Your Ref: MP 09_0187 MOD 3

MODIFICATION REQUEST – SECTION 75W MODIFICATION TO MIXED USE DEVELOPMENT AT 6-16 ATCHISON ST, ST LEONARDS (MO-09_0187 MOD 3)

I refer to your letter dated 2 June 2014 concerning the above matter. The proposed modifications have been reviewed by Council Planners and are not supported the reasons set out below.

NORTH ELEVATION

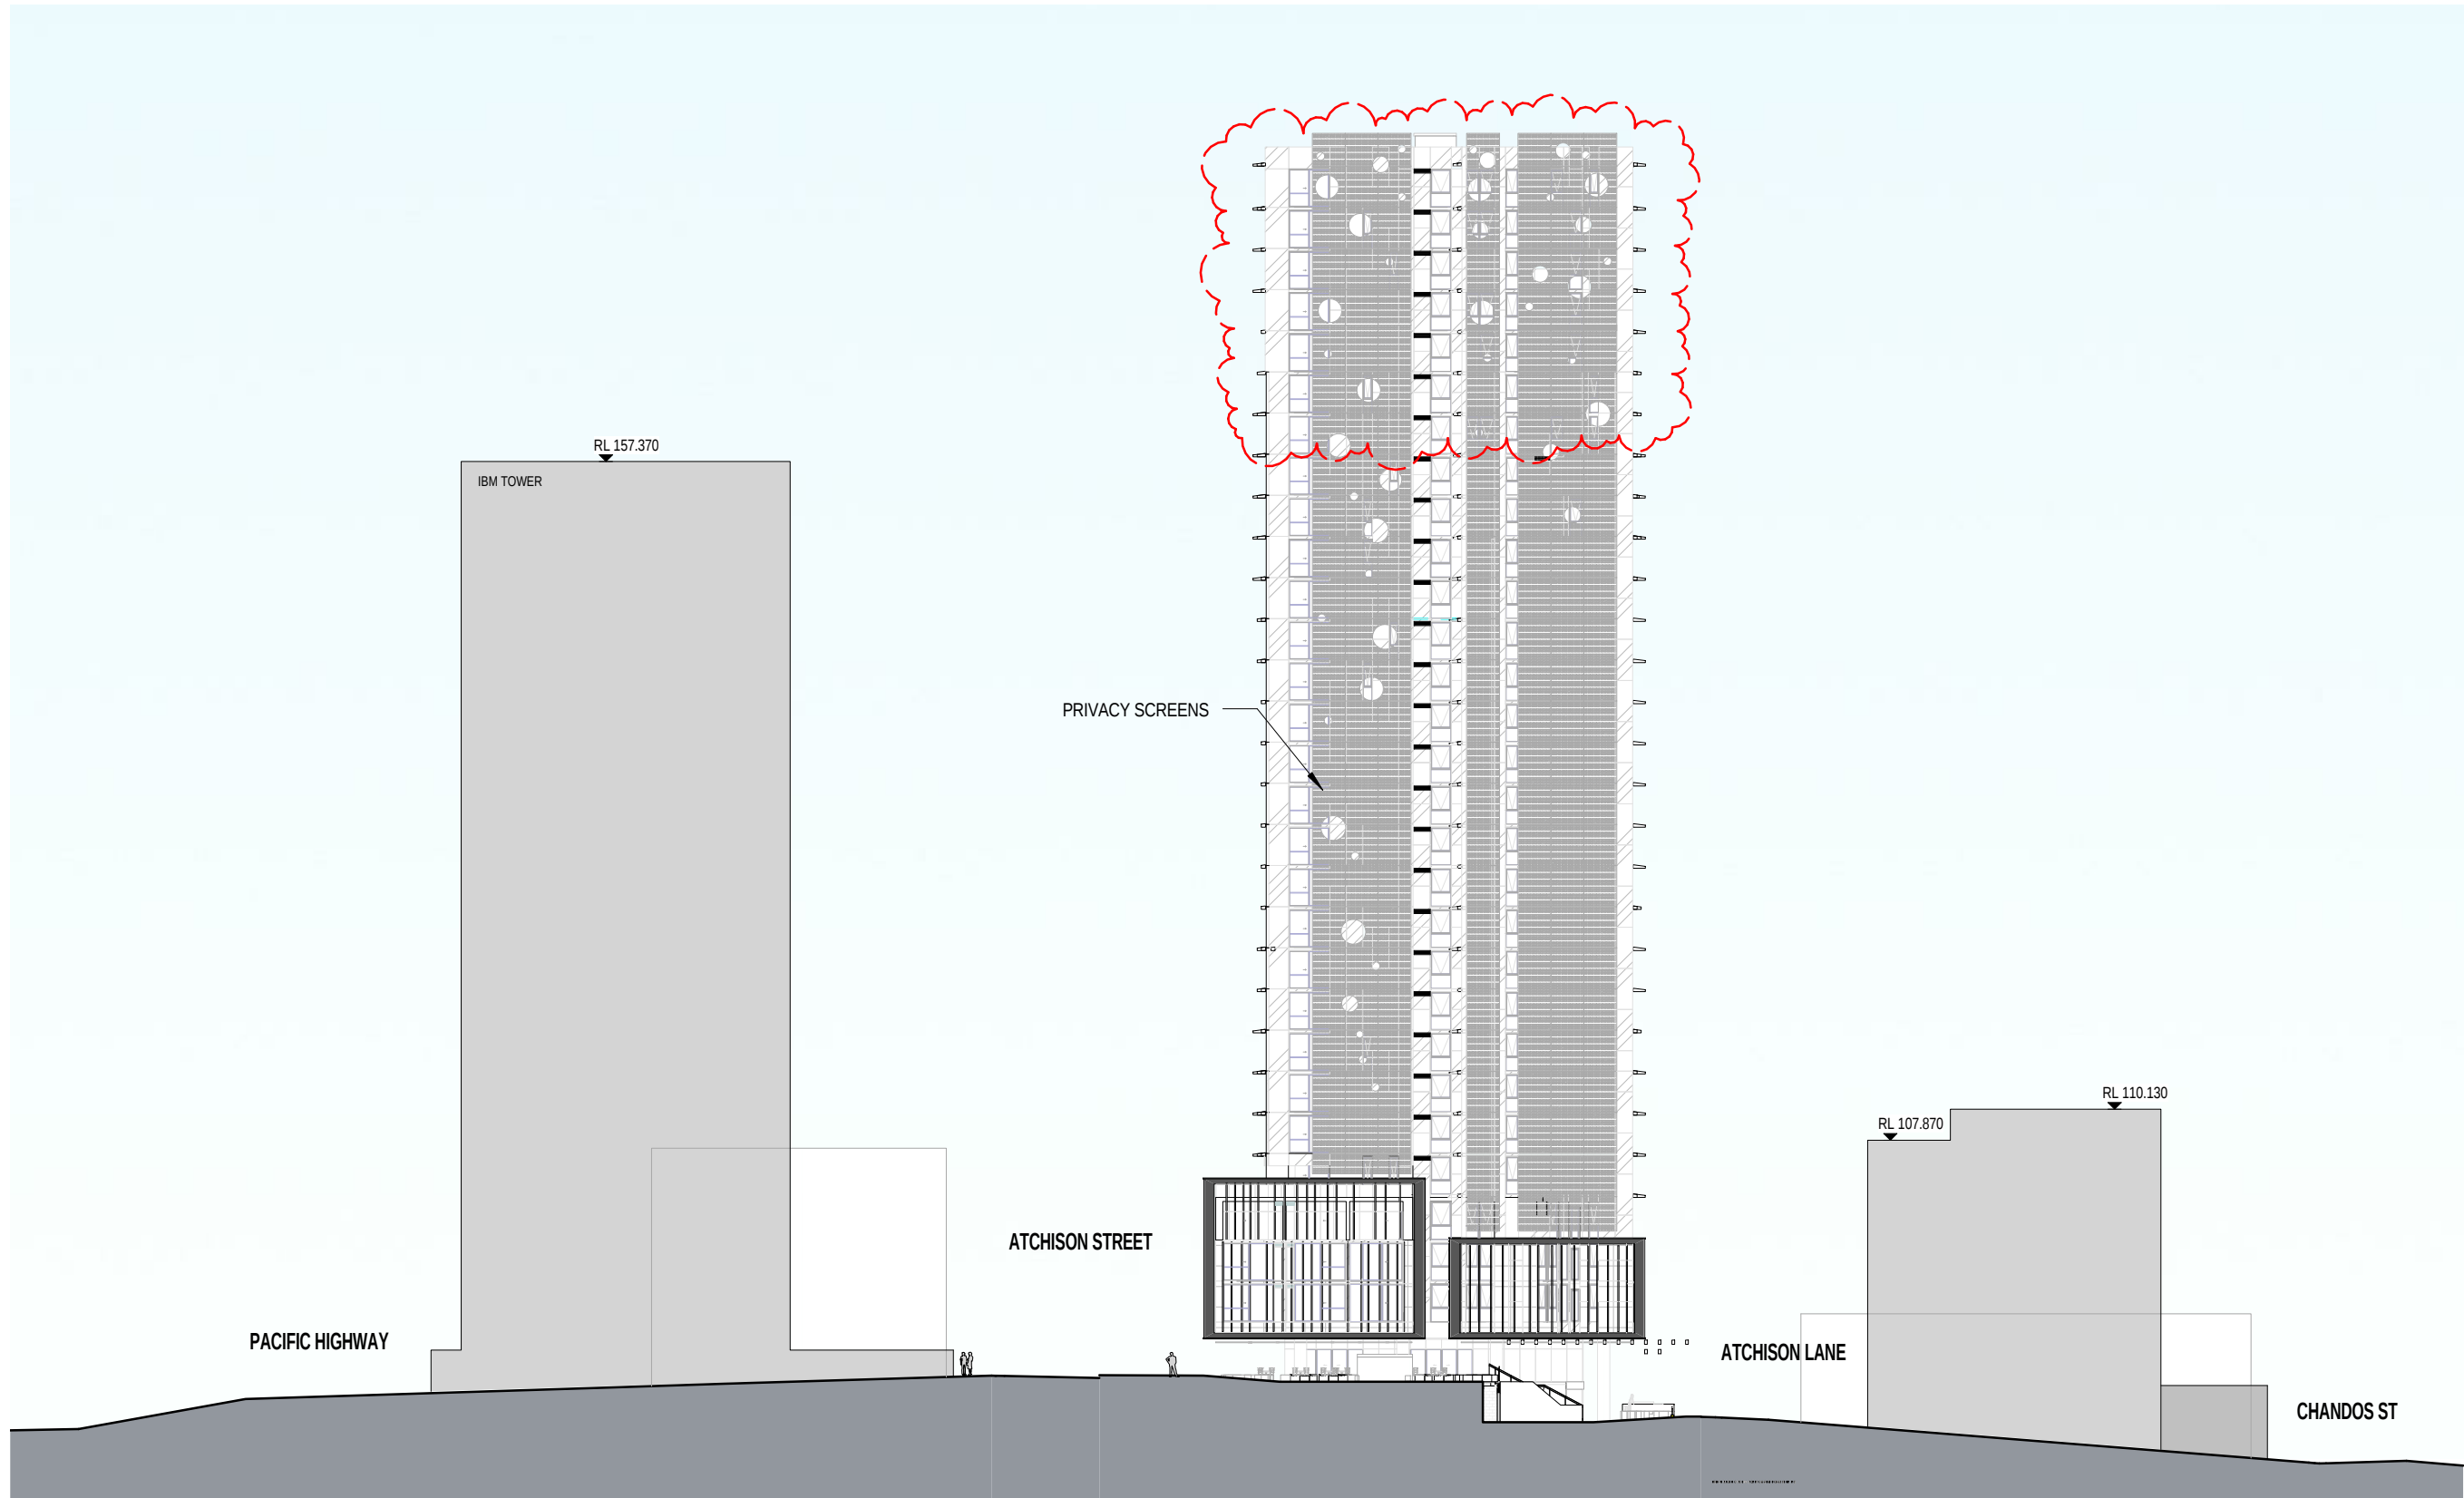
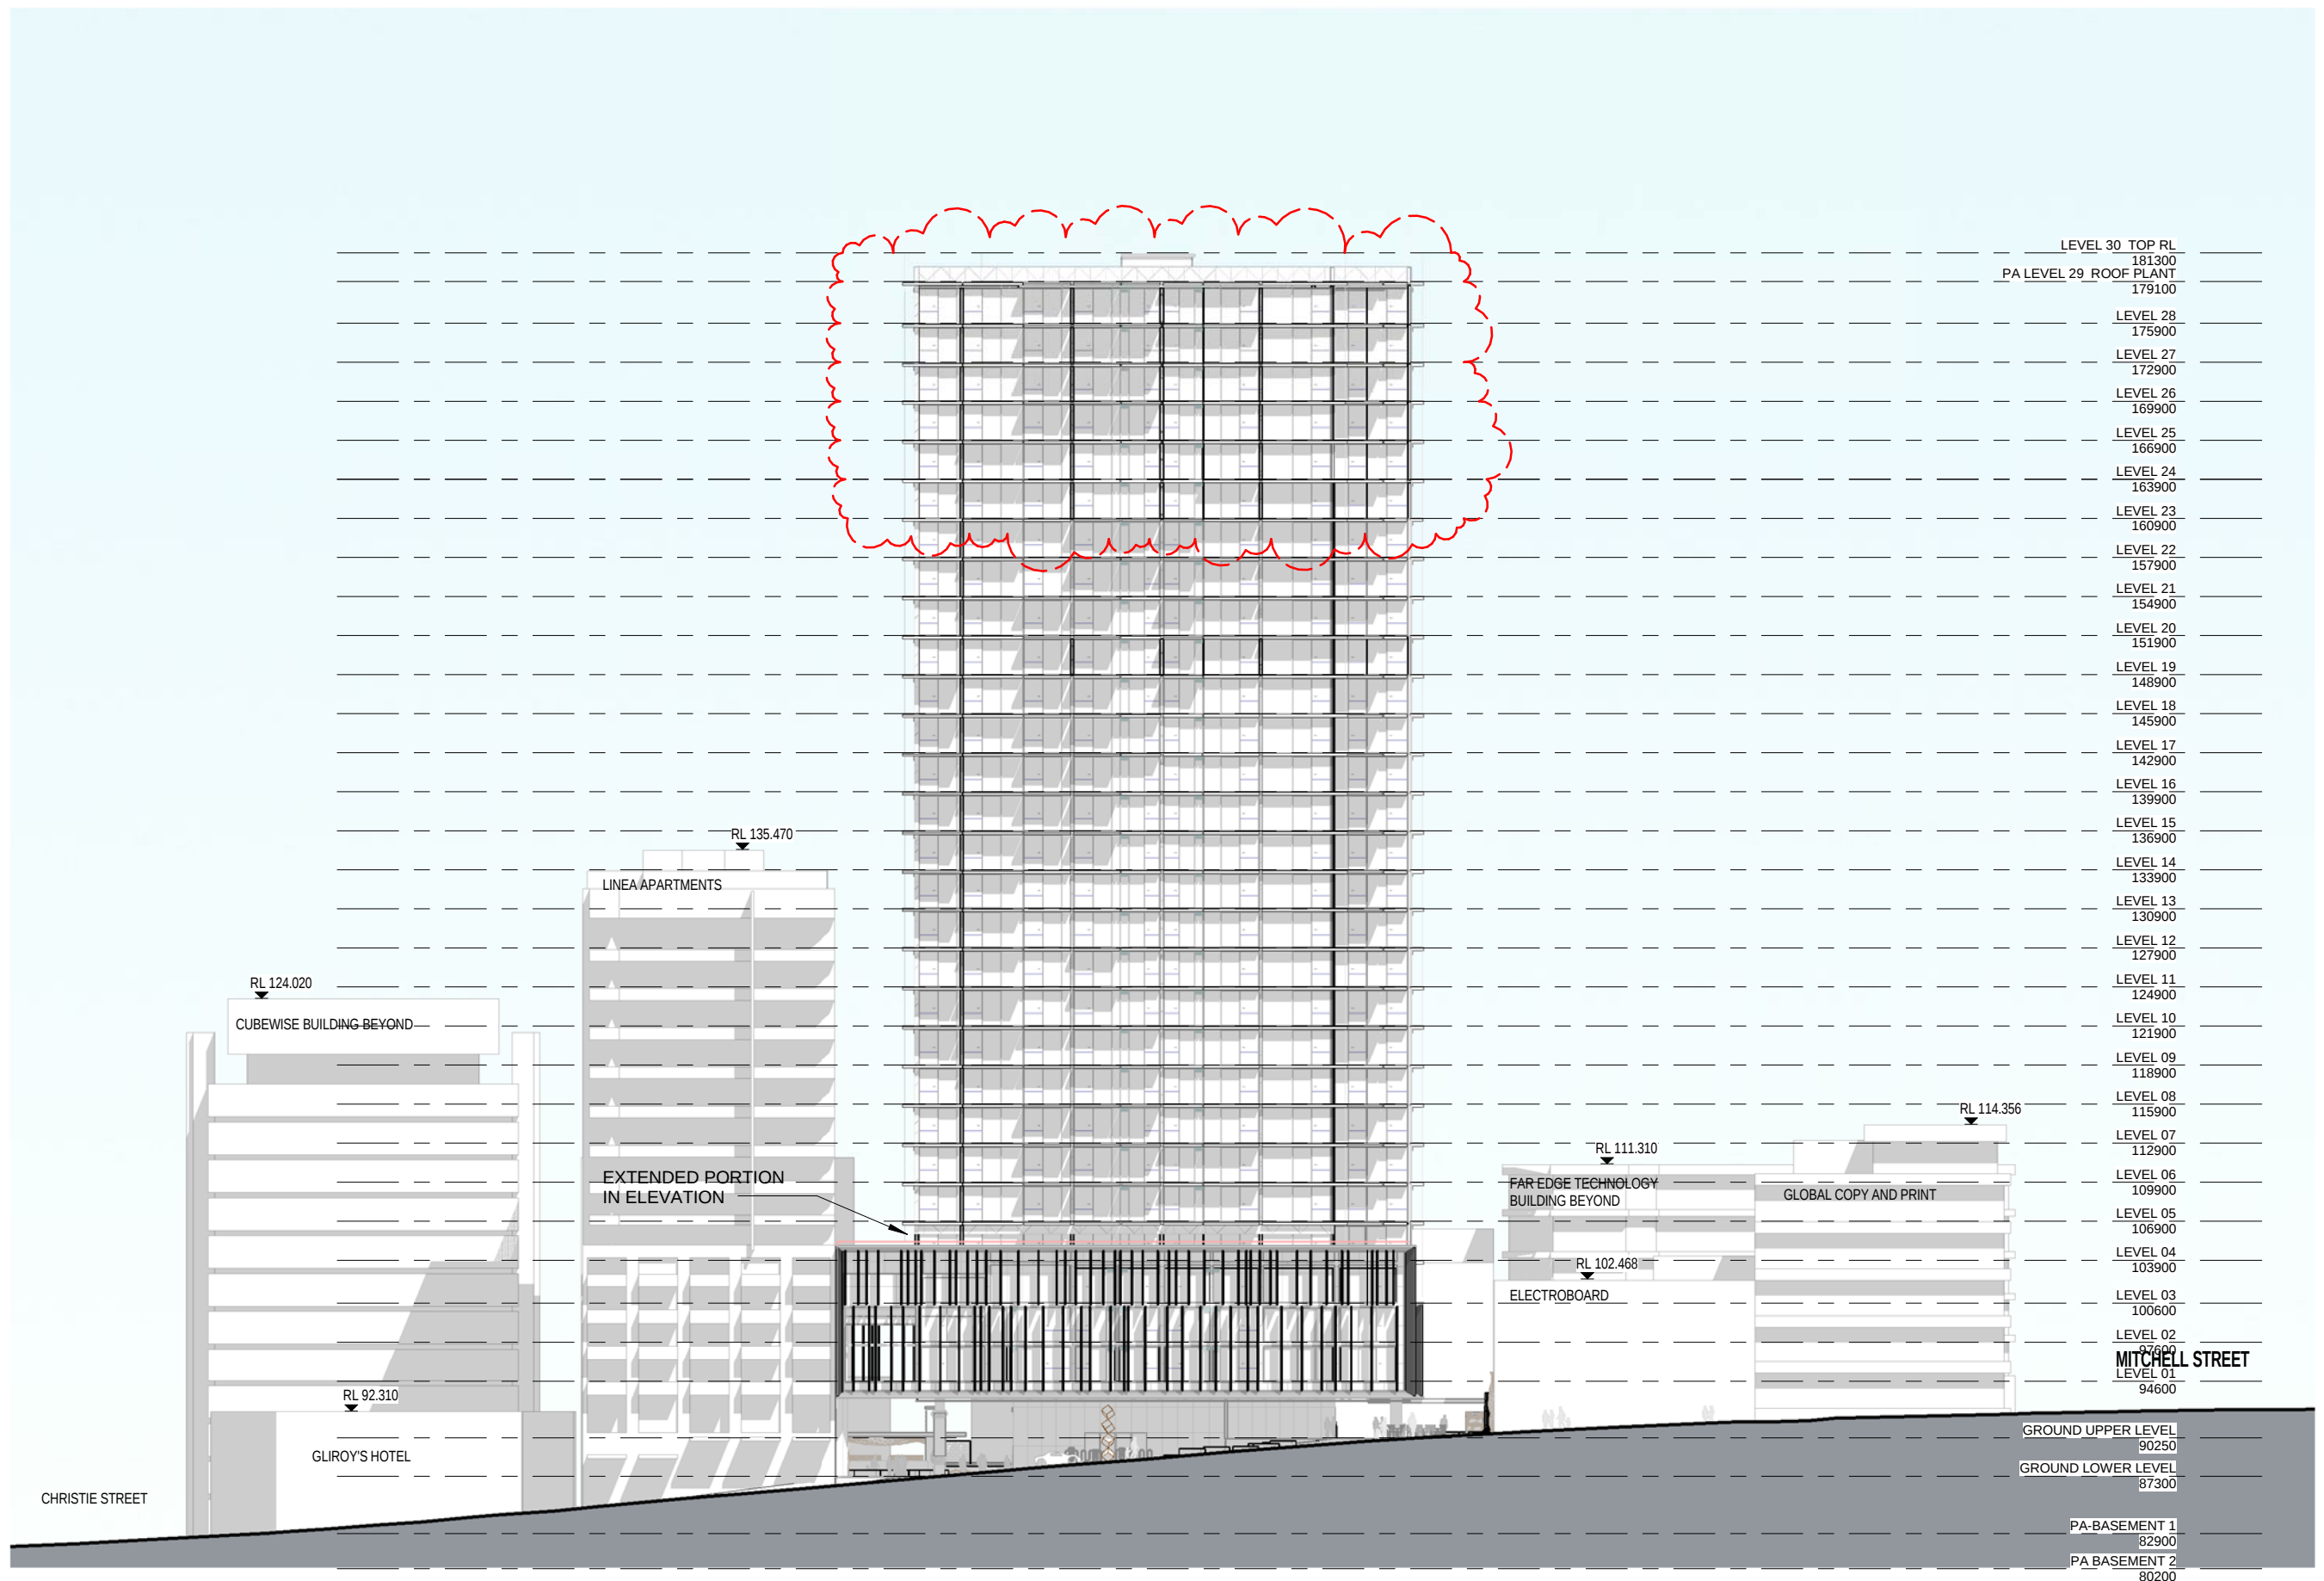
The proposed additional building height to be increased from RL167.3m (82.5m) to RL 181.3m (94m) AHD is strongly opposed. The North Sydney LEP 2013 sets a maximum Building Height of 49m on the site. Council strongly opposed the approved building height and form at the time. The proposed modification is seeking to reinstate an additional 4 levels that were previously refused by the Planning and Assessment Commission as part of the original development consent. This additional height continues to be without merit and should not be supported. The approval as it stands is considered to have compromised the orderly development of land in St Leonards.

The proposal fails to provide a clear understanding of the proposed height in relation to the local context. Tables comparing the proposal to other buildings combine data in storeys, RLs and metres which does not provide an accurate assessment of the proposed height against the local context, including The Forum. Similarly, the section diagrams are schematic at best.
